From: Sue Howell
Sent: 08 May 2017 17:39
To: Planning.Responses
Cc: Simon Davis
Subject: RE: Planning Consultation on AW/73/17/DOC

APPLICATION **AW/73/17/DOC**
NO:

Registered: 07-MAR-17
Site Address: Norworth Kings Parade Aldwick PO21 2QR

Works: imposed under AW/179/14/PL relating to condition 4 for landscape scheme & 5 for surface water drainage details.

PROJECT	Kings Parade	DATE	05/03/17
TITLE	Landscaping Plan	DRG NO	IBA/458/LA 1
SCALE	As Noted	REVISIONS	A

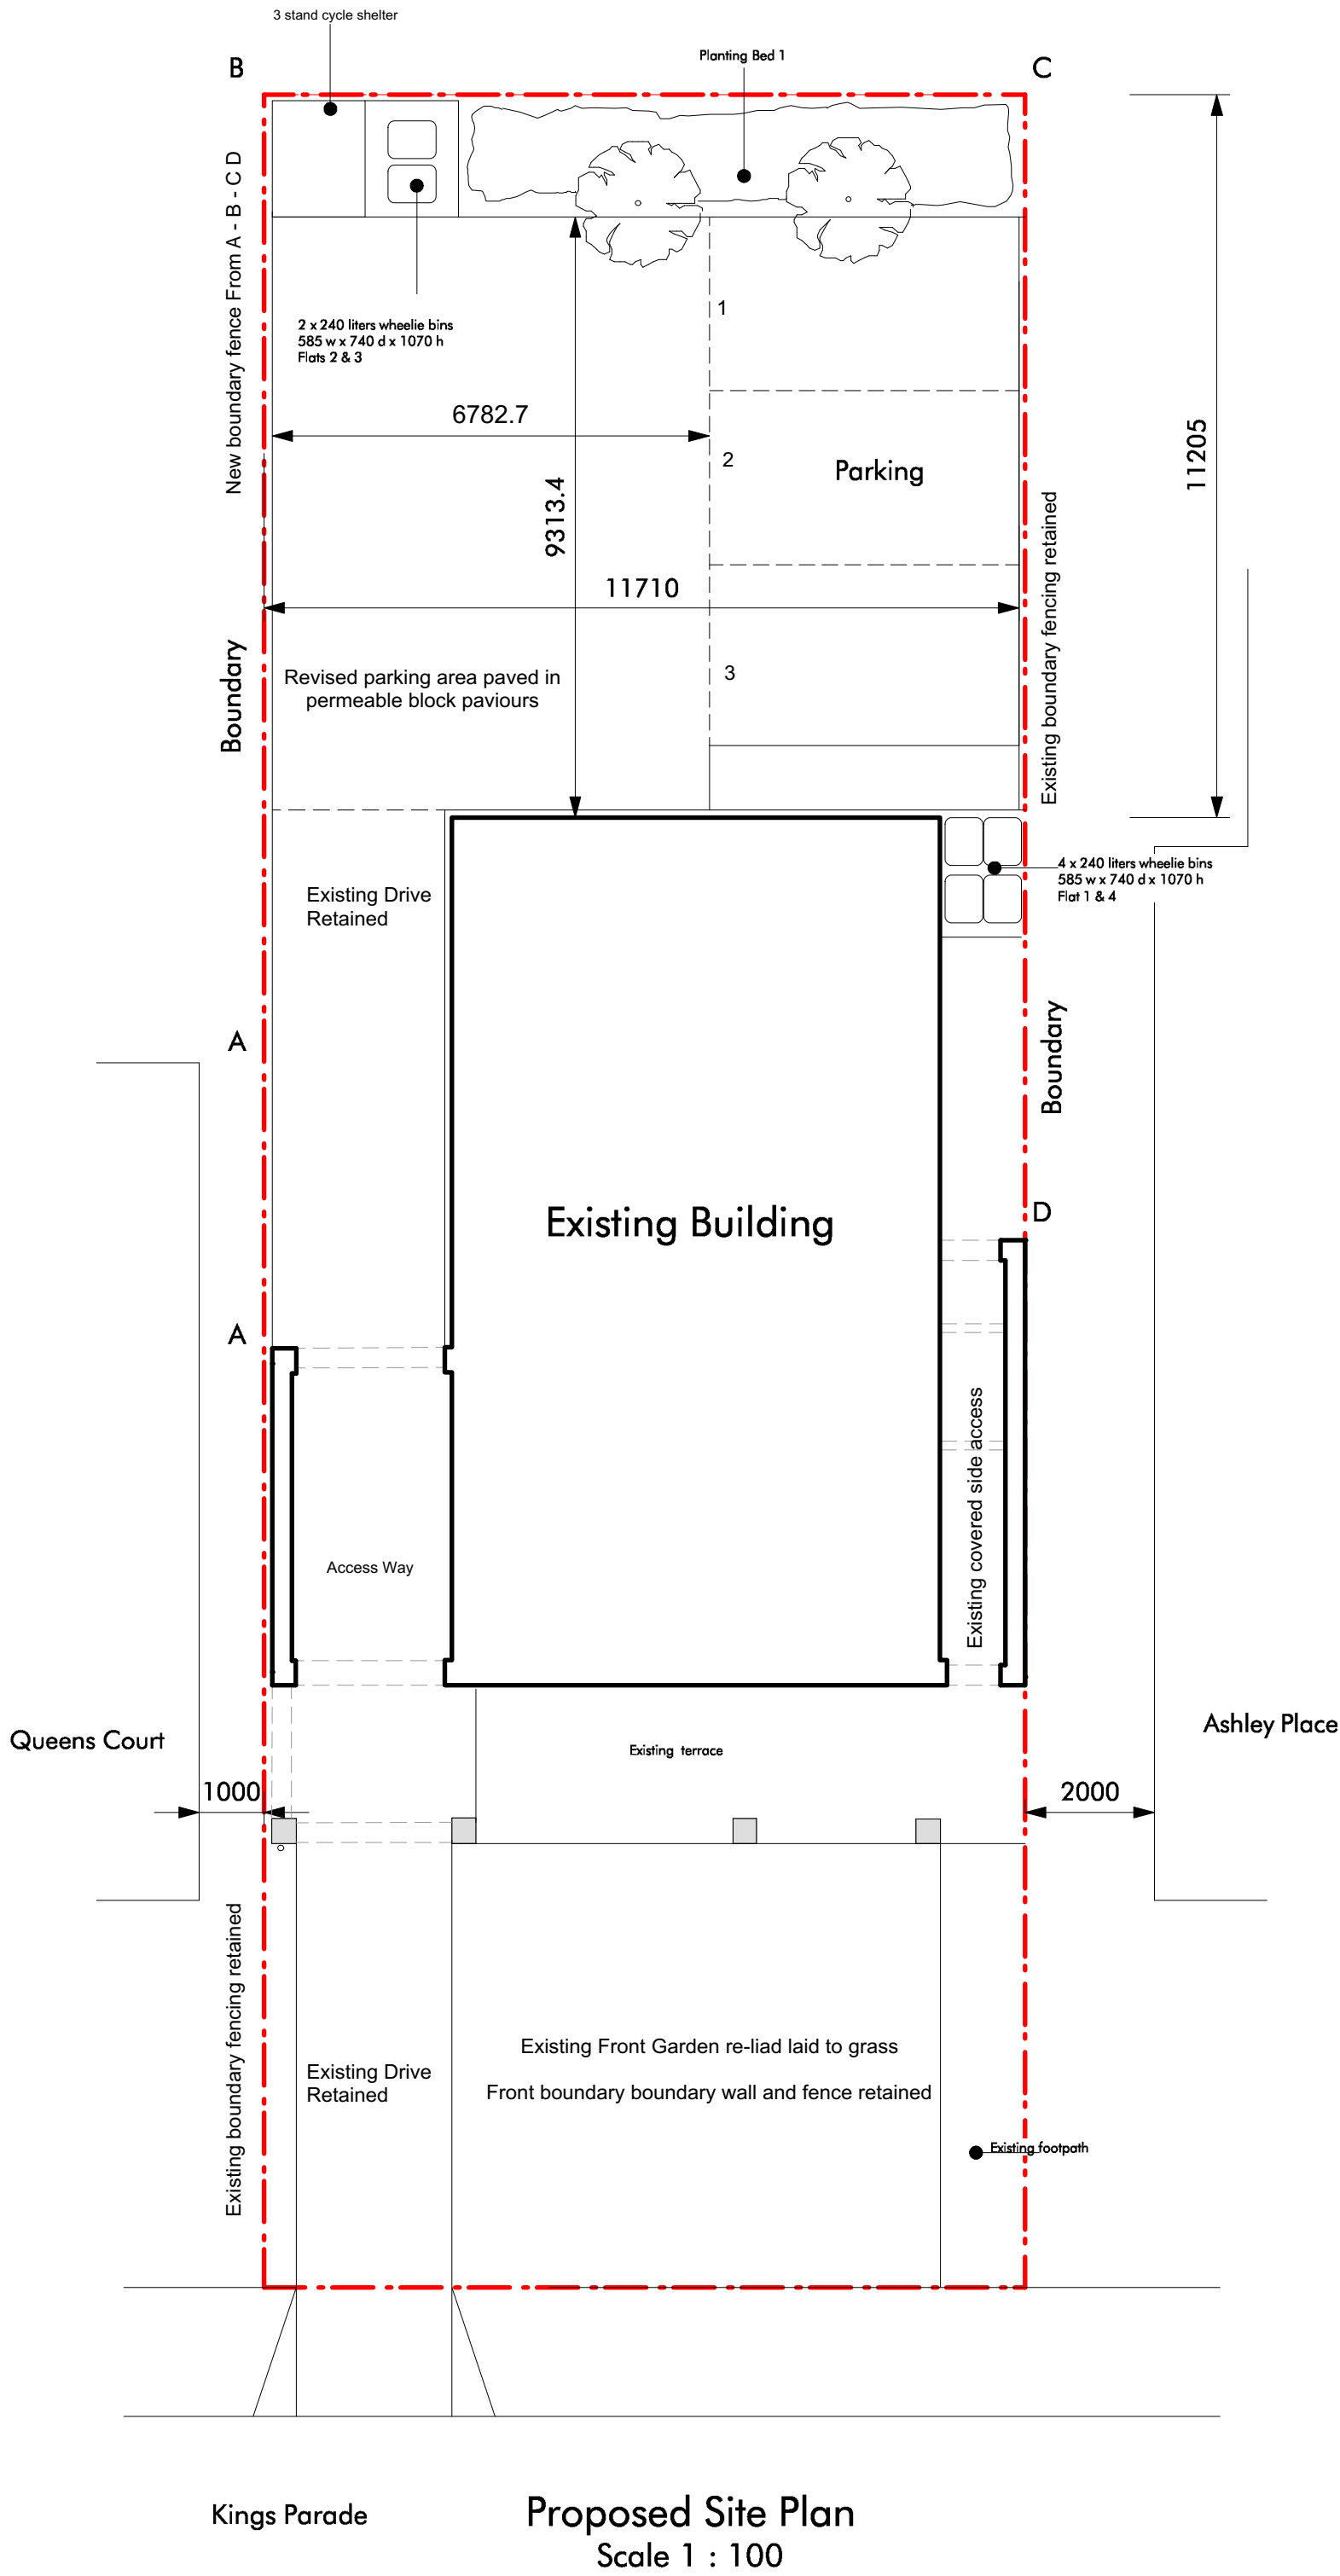
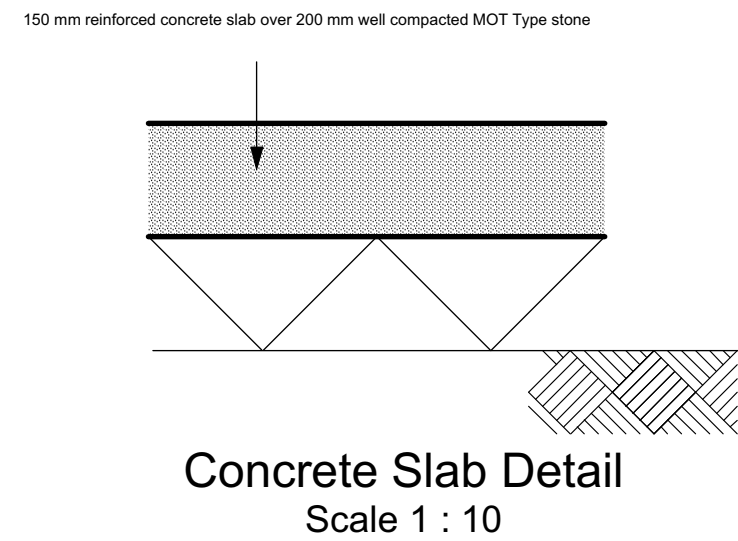
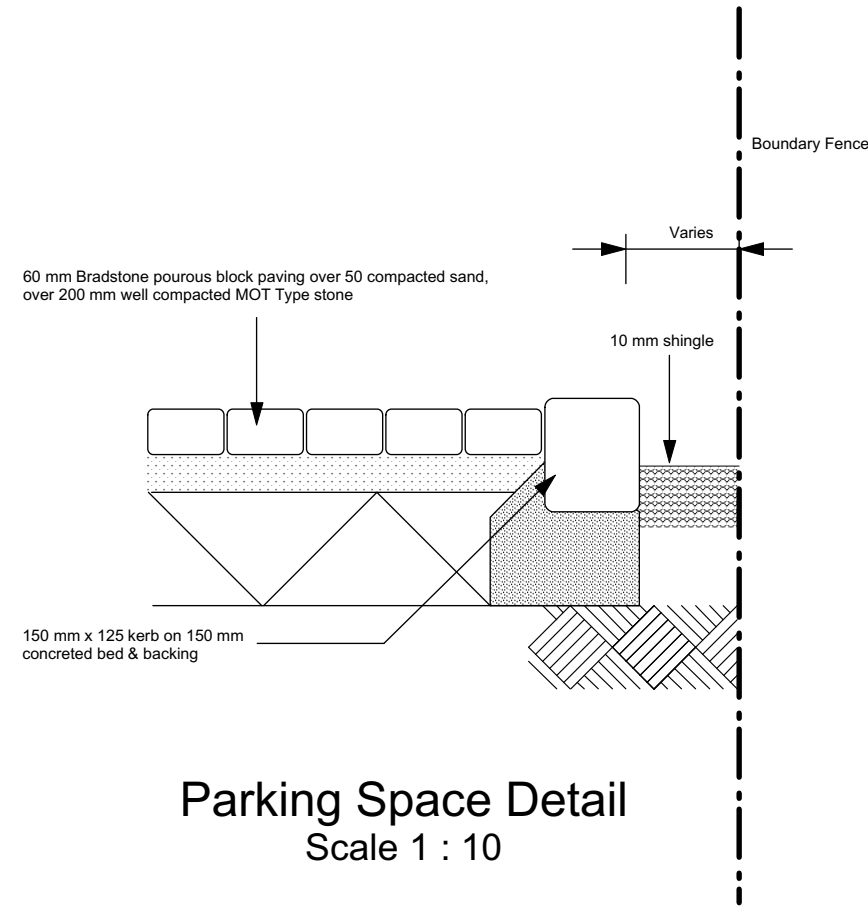
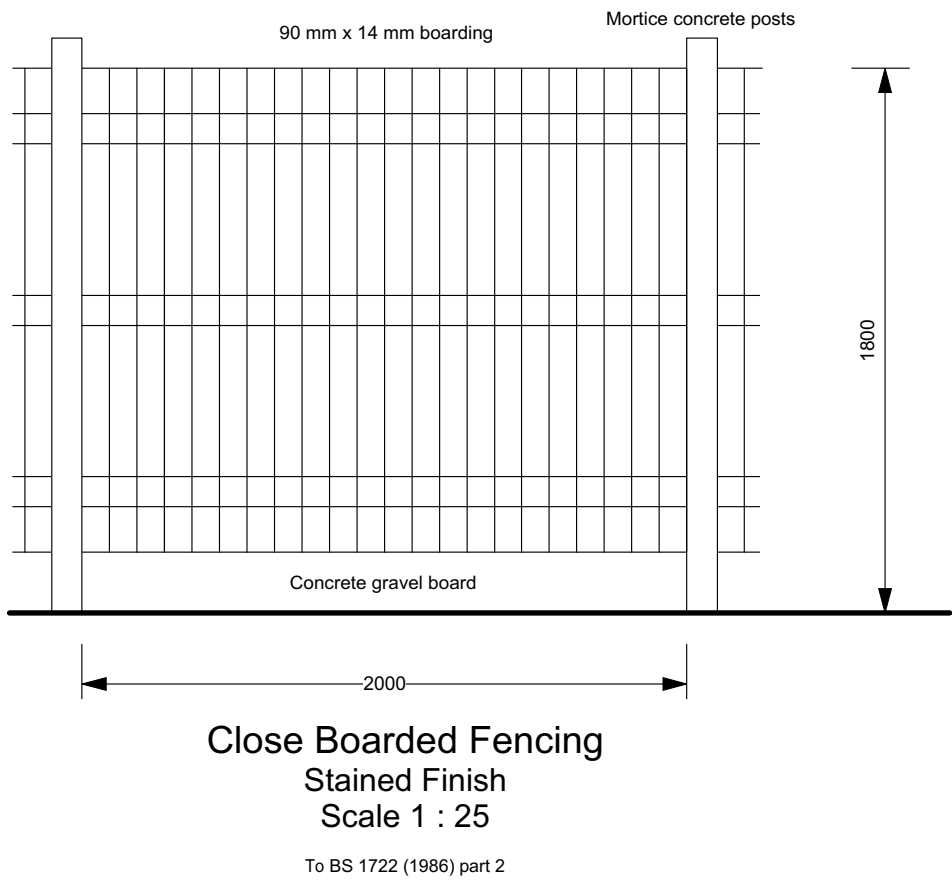
Dwg no IBA/458/LA/1 needs to detail the landscape proposals in plan form detailing species choice, **plant quantities and size** at time of planting. We note that the proposals have changed from 3no Silver Birch to now 2no Prunus Amanogowa, details of the proposed spec needs to be submitted for all soft landscaping.
